From: Contact Centre (CRM) <contact@ribblevalley.gov.uk>
Sent: 06 October 2024 11:38
To: Planning
Subject: Planning Application Comments - 3/2024/0585 FS-Case-652403507

Planning Application Reference No.: 3/2024/0585

Address of Development: 3 Church St, Clitheroe

1 Working-Plan_00-Ground
1:50

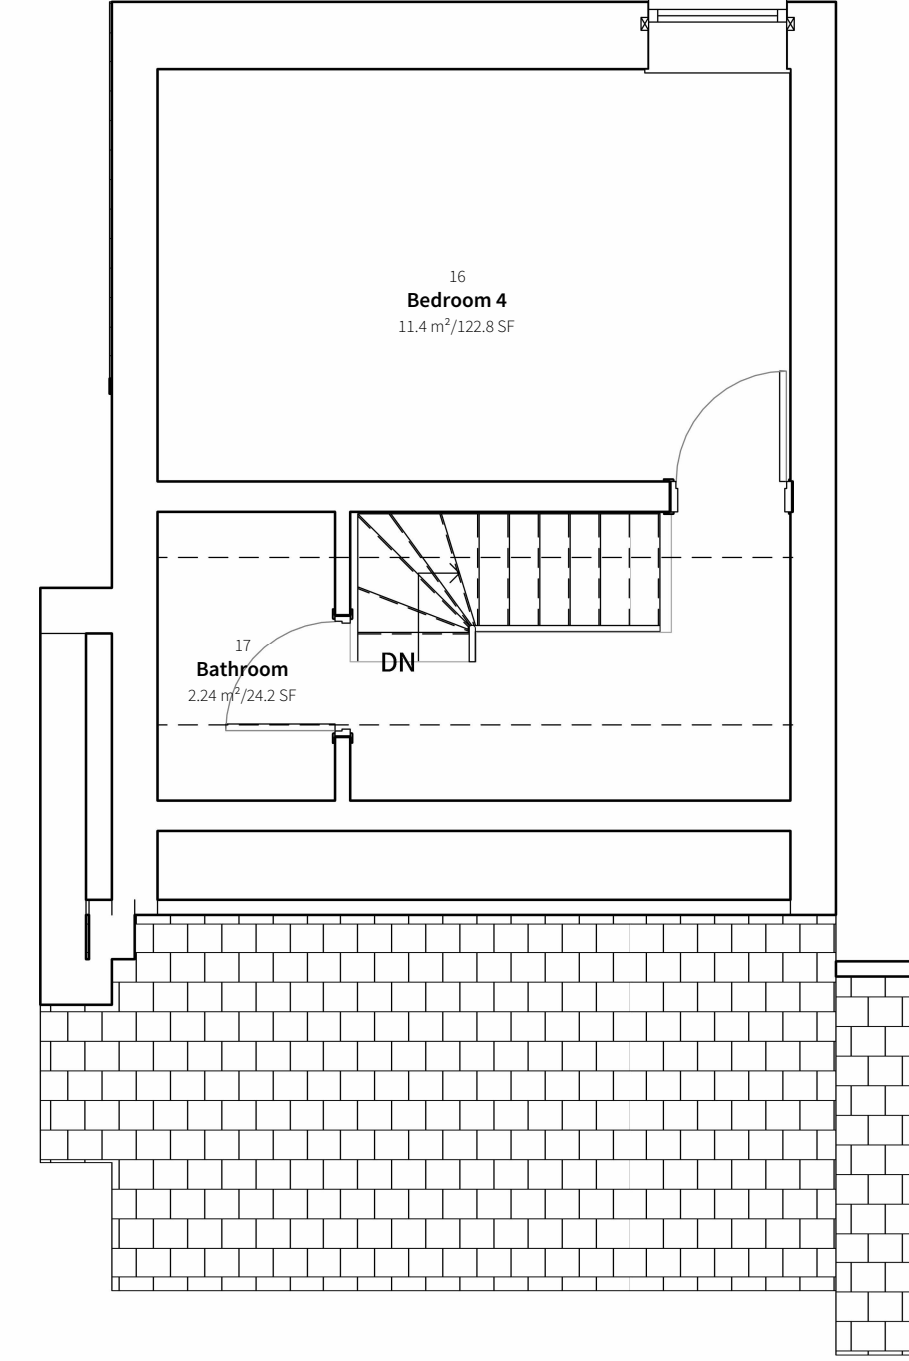
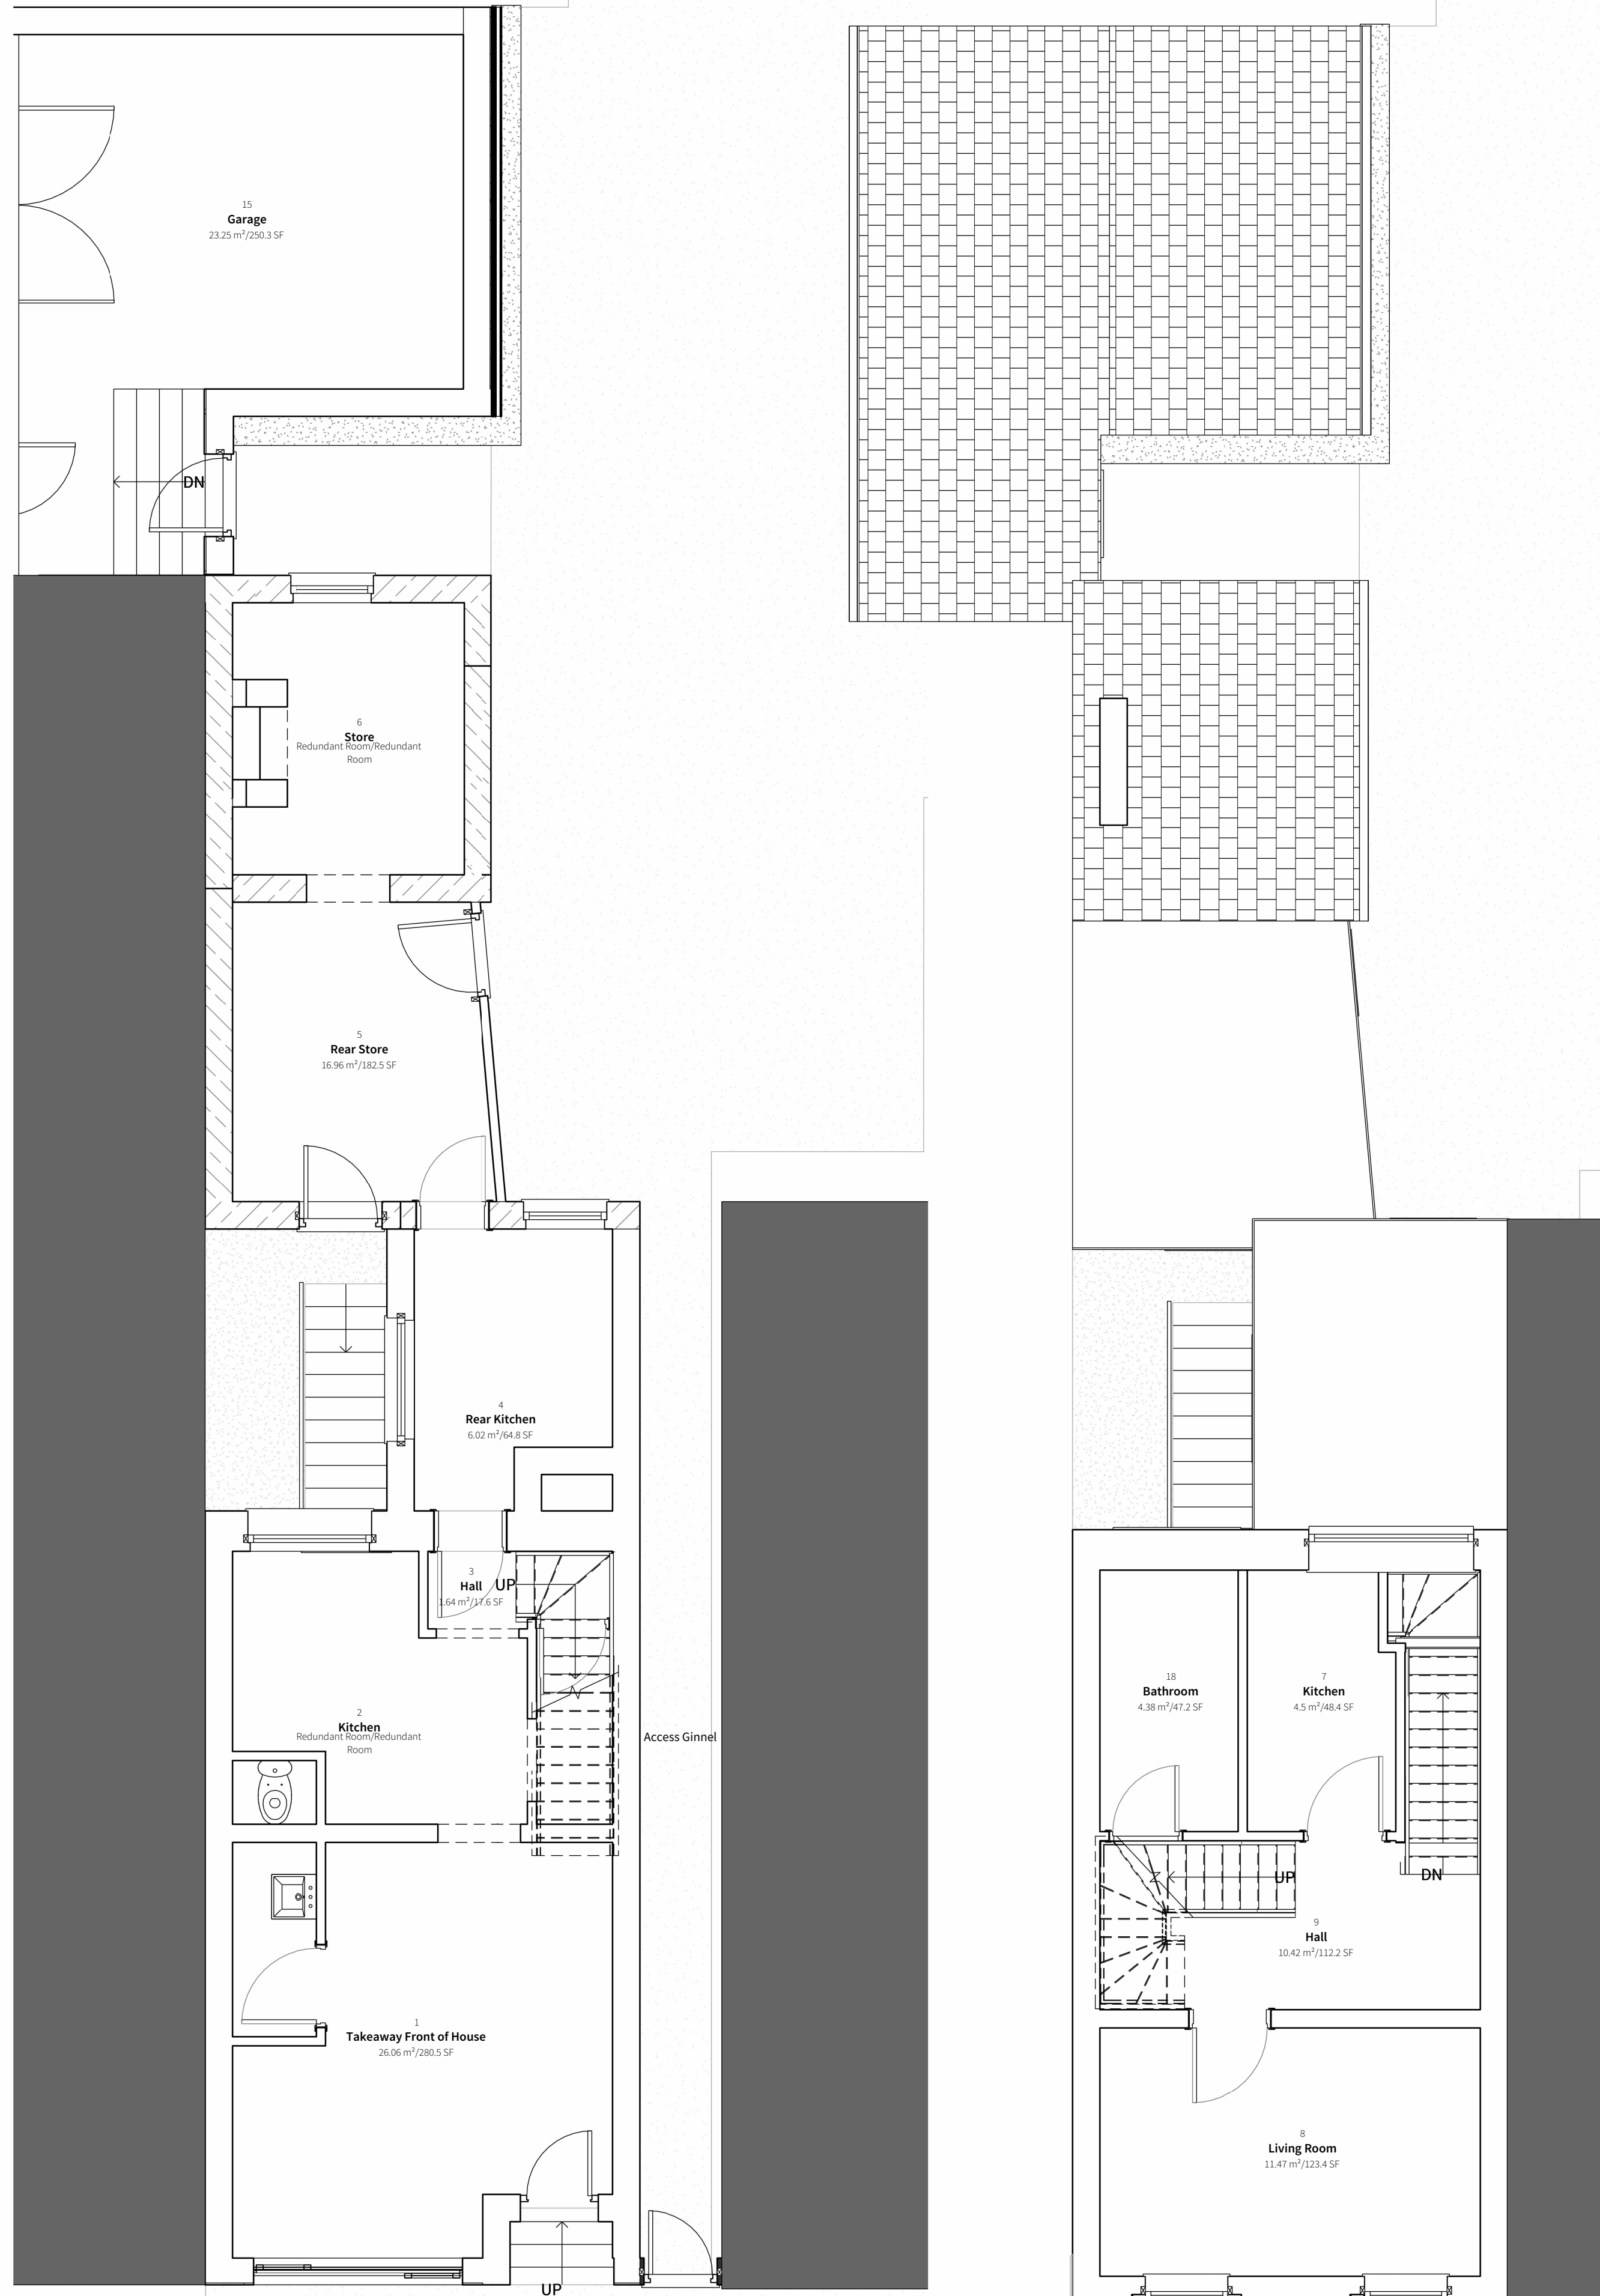
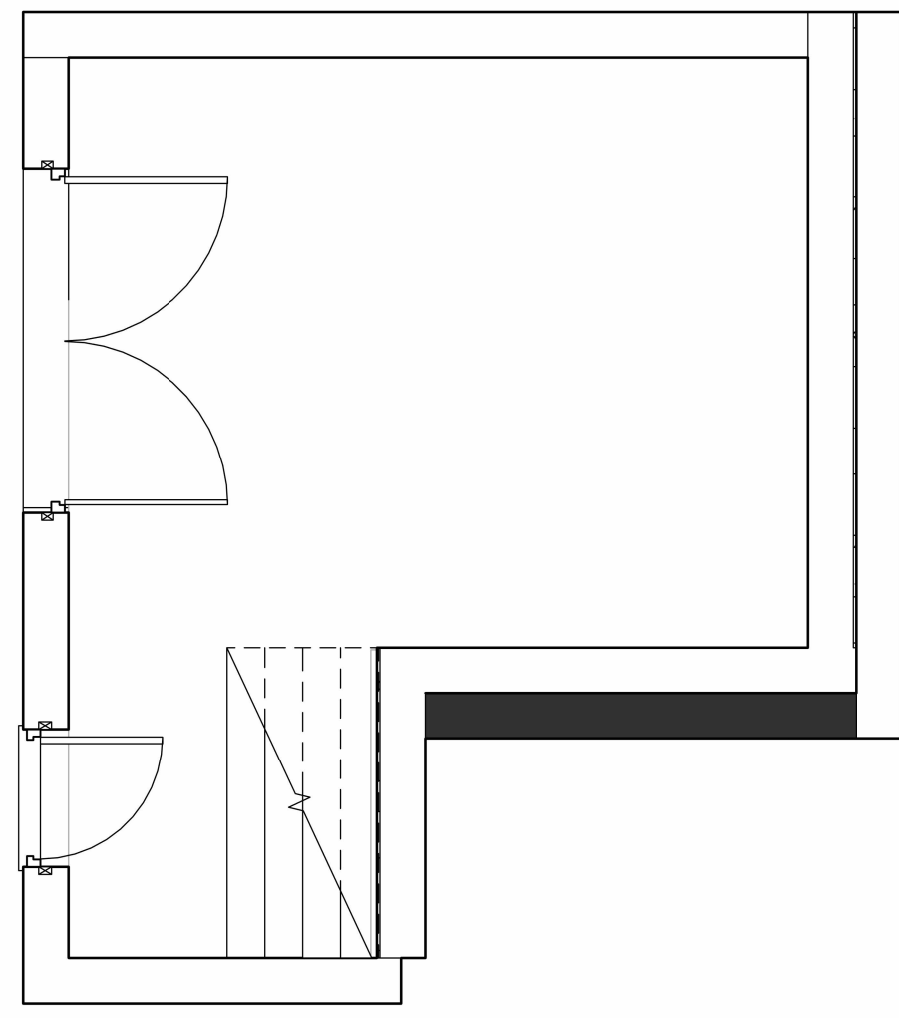
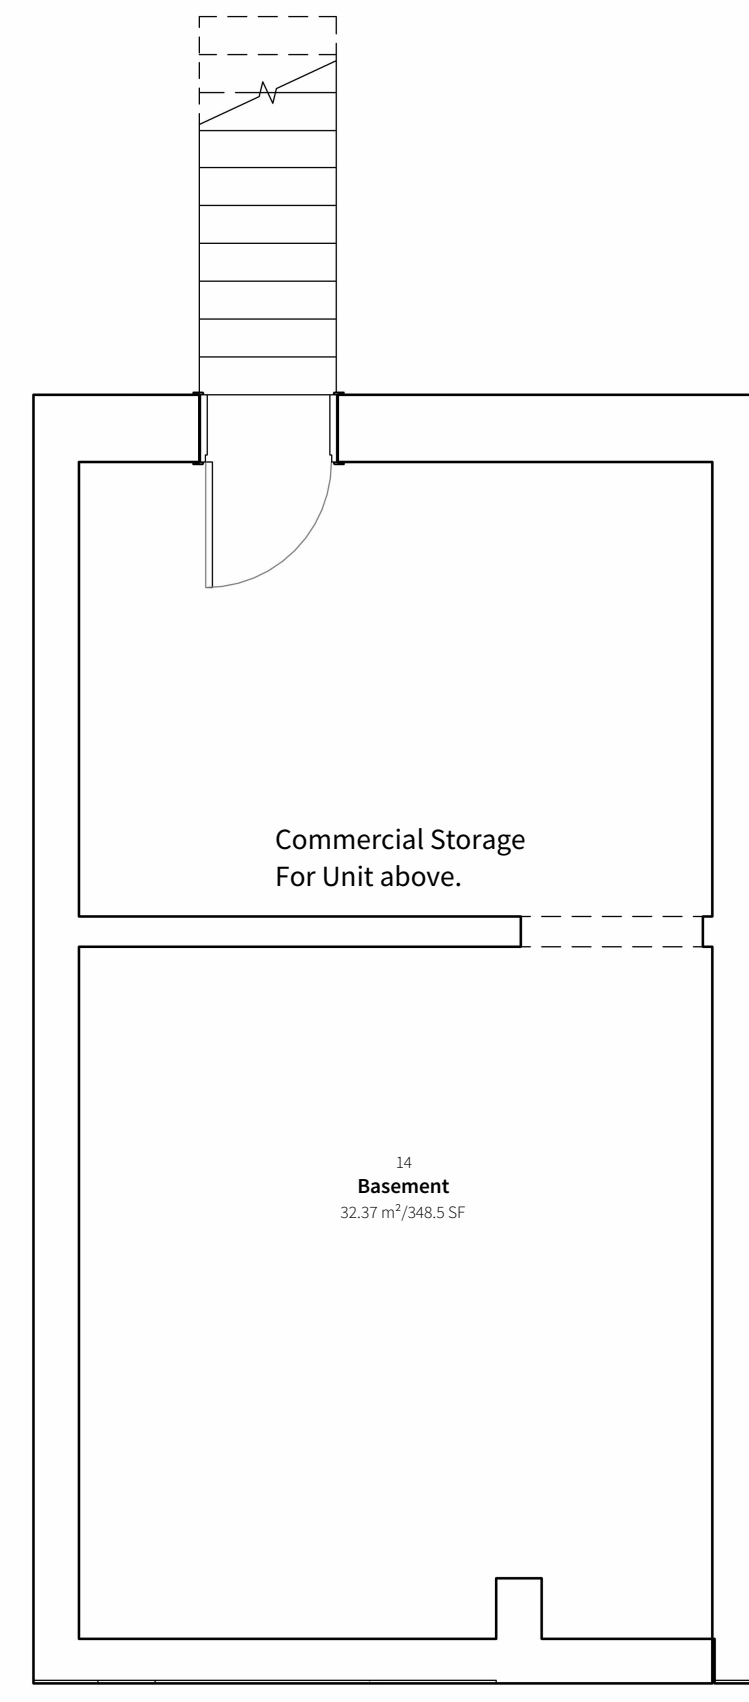
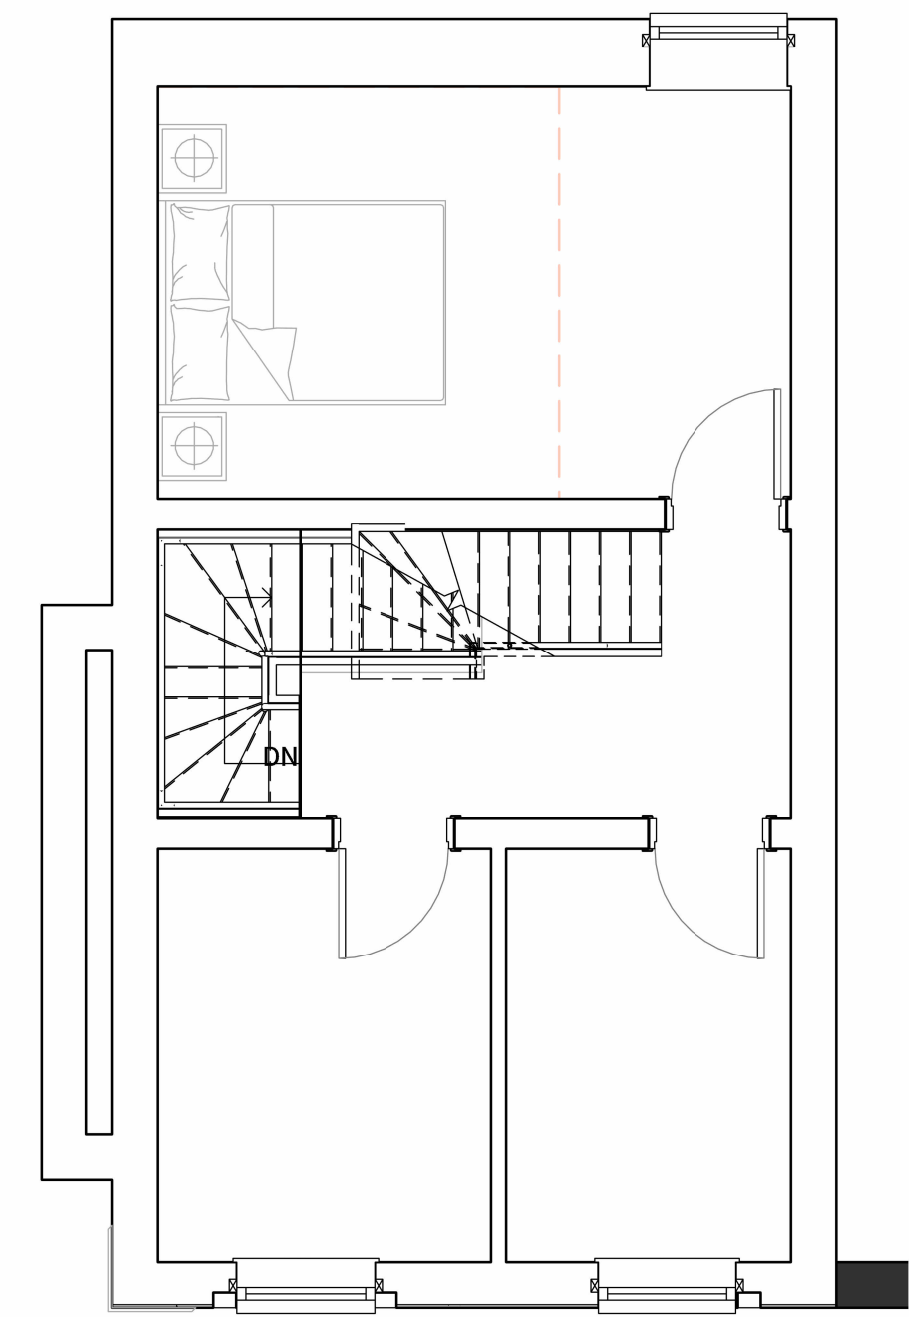
The buildings to the rear (labelled 'store' and 'garage' on the submitted existing site plans) are potentially very old, at least mid-19th century. The existing plans show what seems to be a substantial fireplace in the store building, which is absent from the proposed plans therefore presumably being removed. There are no photos of this in the application so we can't assess its significance.
